Drafted 22 November 2011

Planning Applications, Ribble Valley District
D3-11-0140 land adjacent to High Gill Barn, Tosside

3/2011/0559

DWG -05E

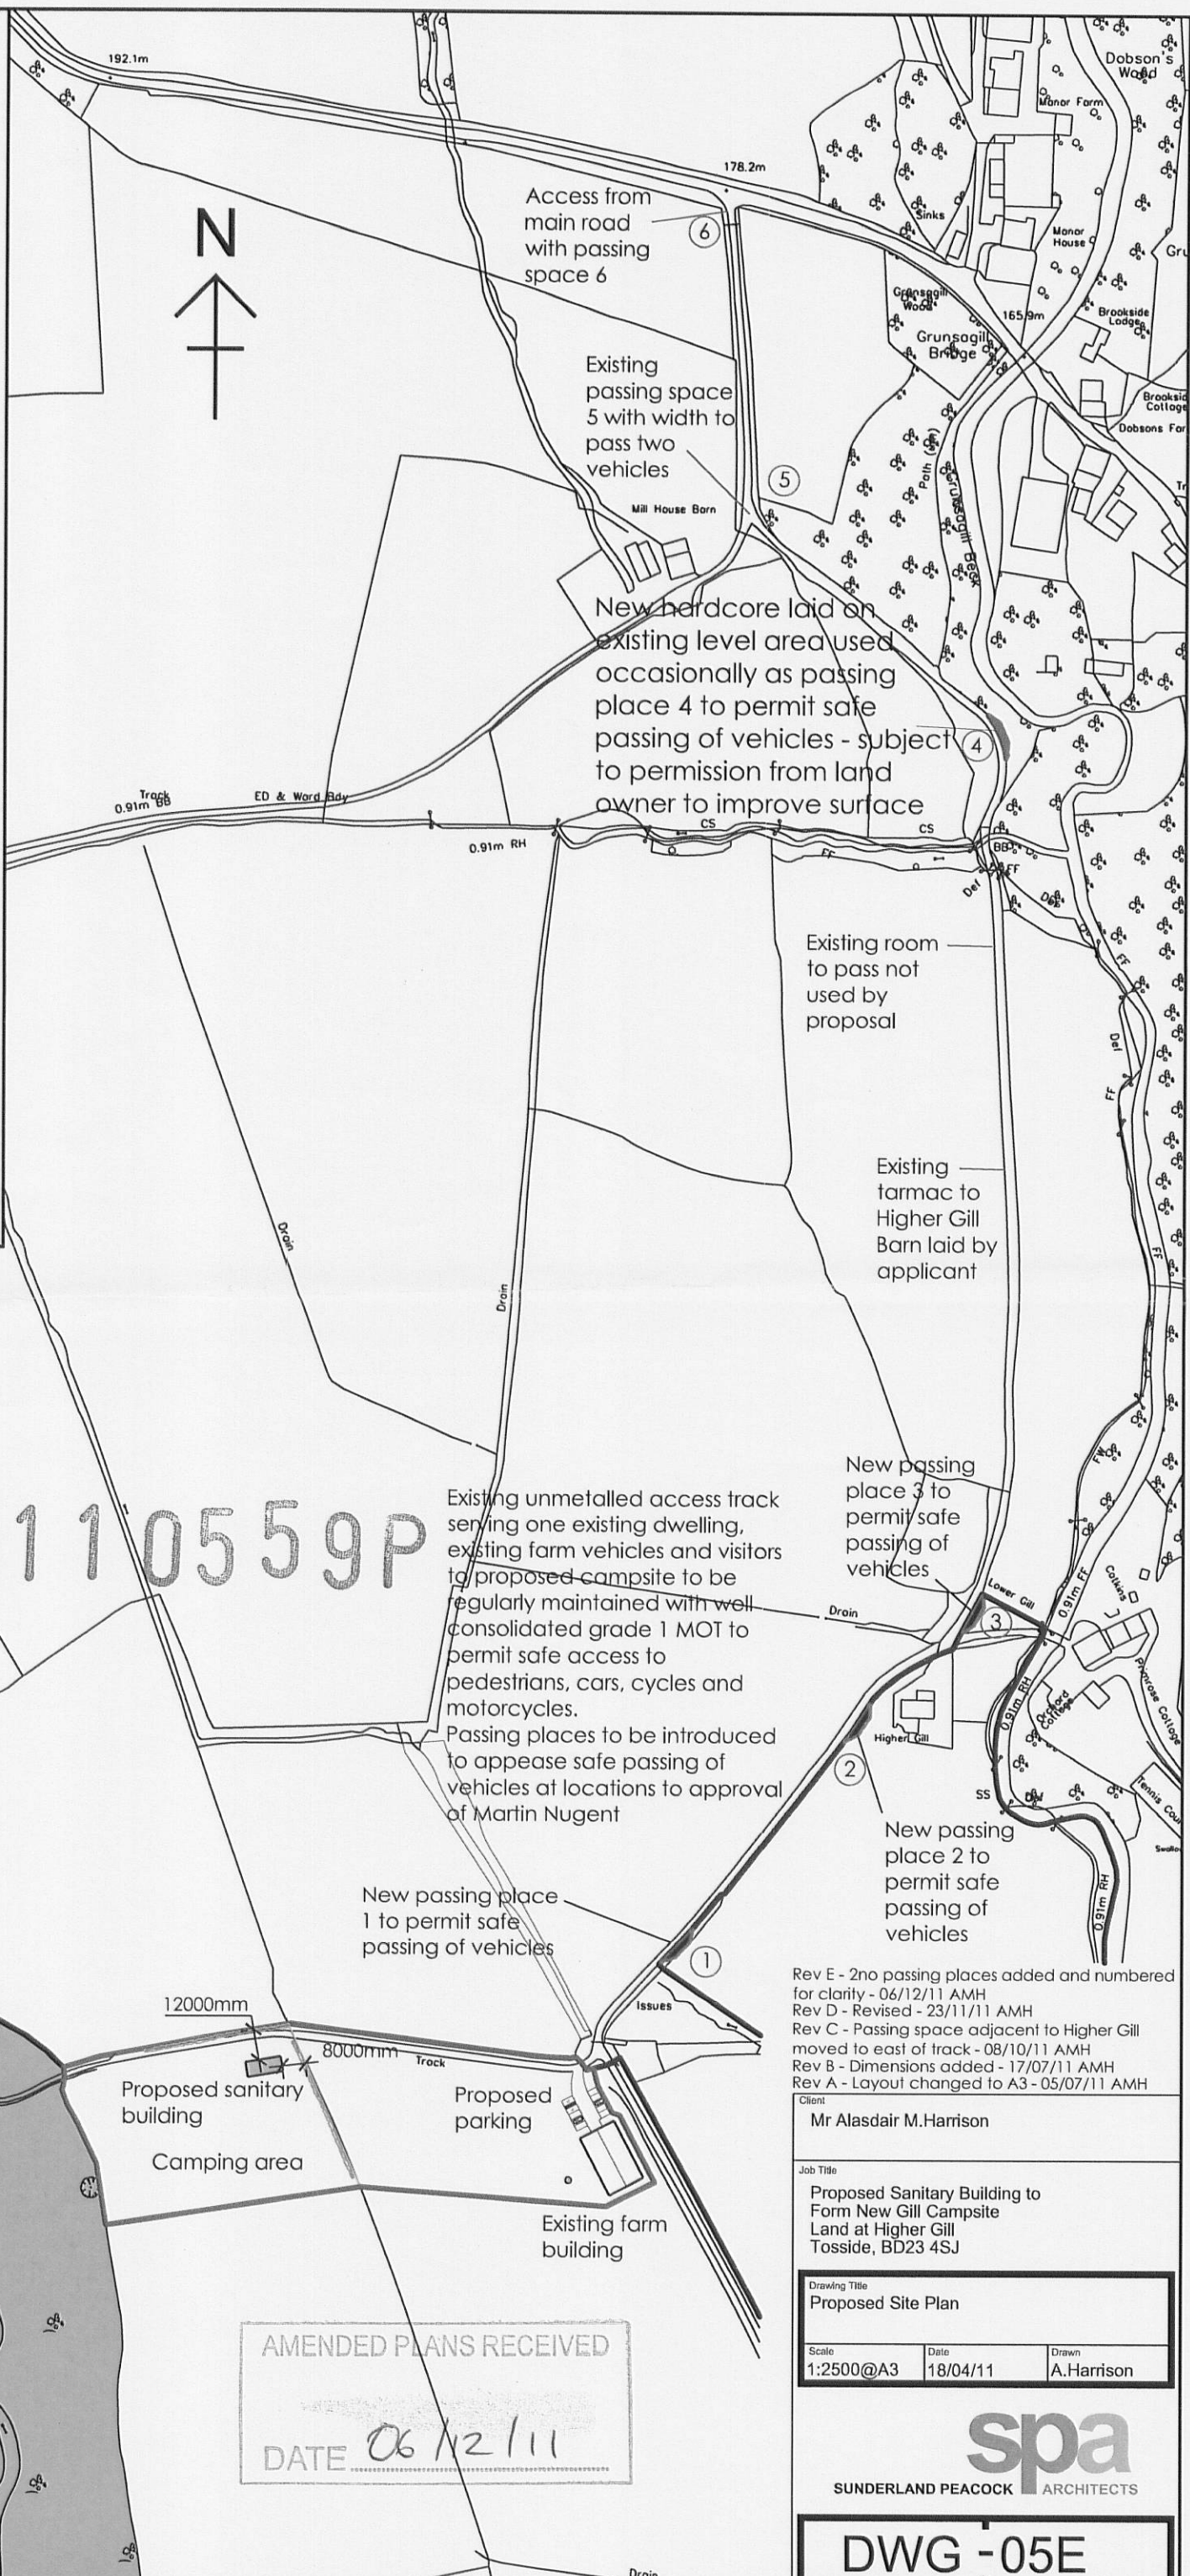
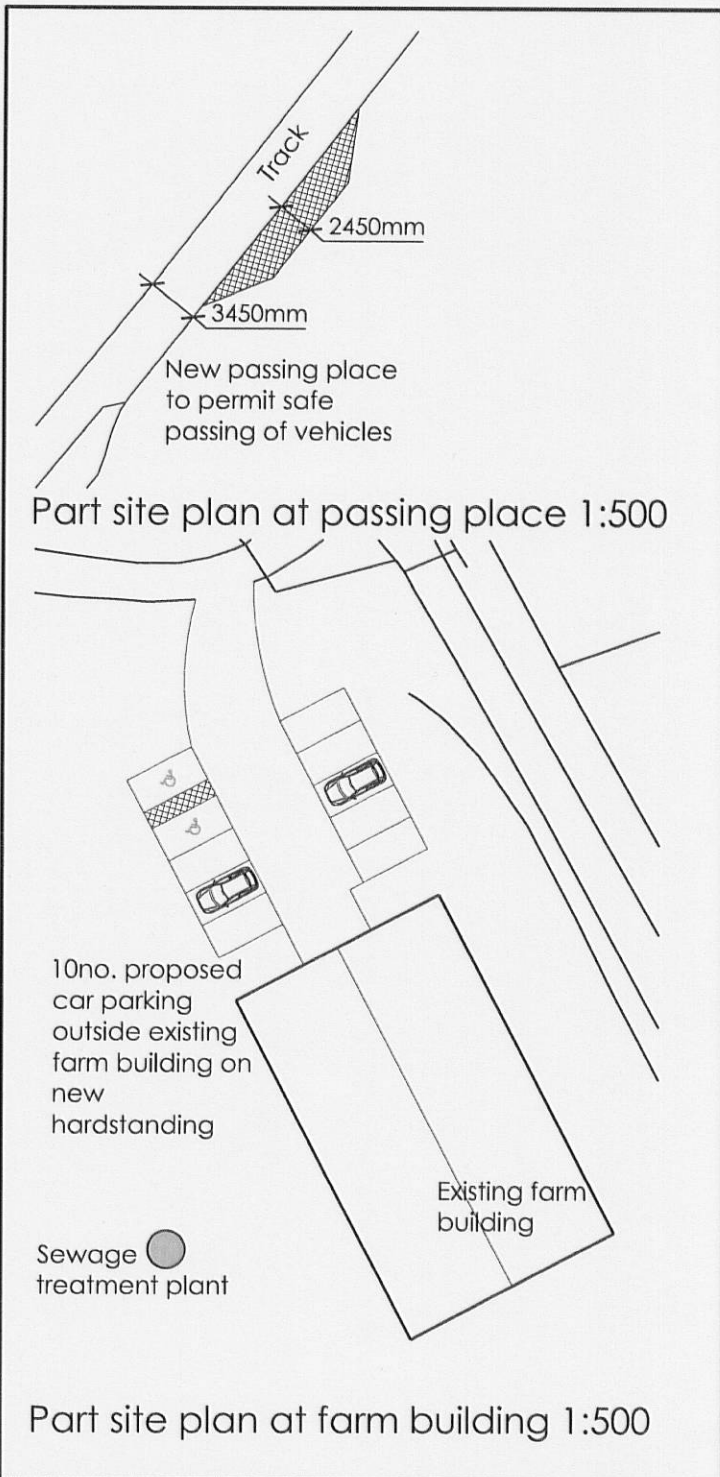
The proposed improvements to the access road identified on Dwg-05 and dated 18 April 2011, identified significant highway safety benefits to bring this track up to a standard consistent with a route suitable for the general public. The three passing places shown provided a safe means of access for the public travelling to the site.

It is apparent that two of these passing places are sited on land that is not under the control of the applicant. Furthermore, the owner of this land has indicated that they will not permit the construction of the passing places as previously agreed.

As there is no prospect of providing an alternative location for the passing places on the applicant's land, I am recommending refusal of this application on highway safety grounds.
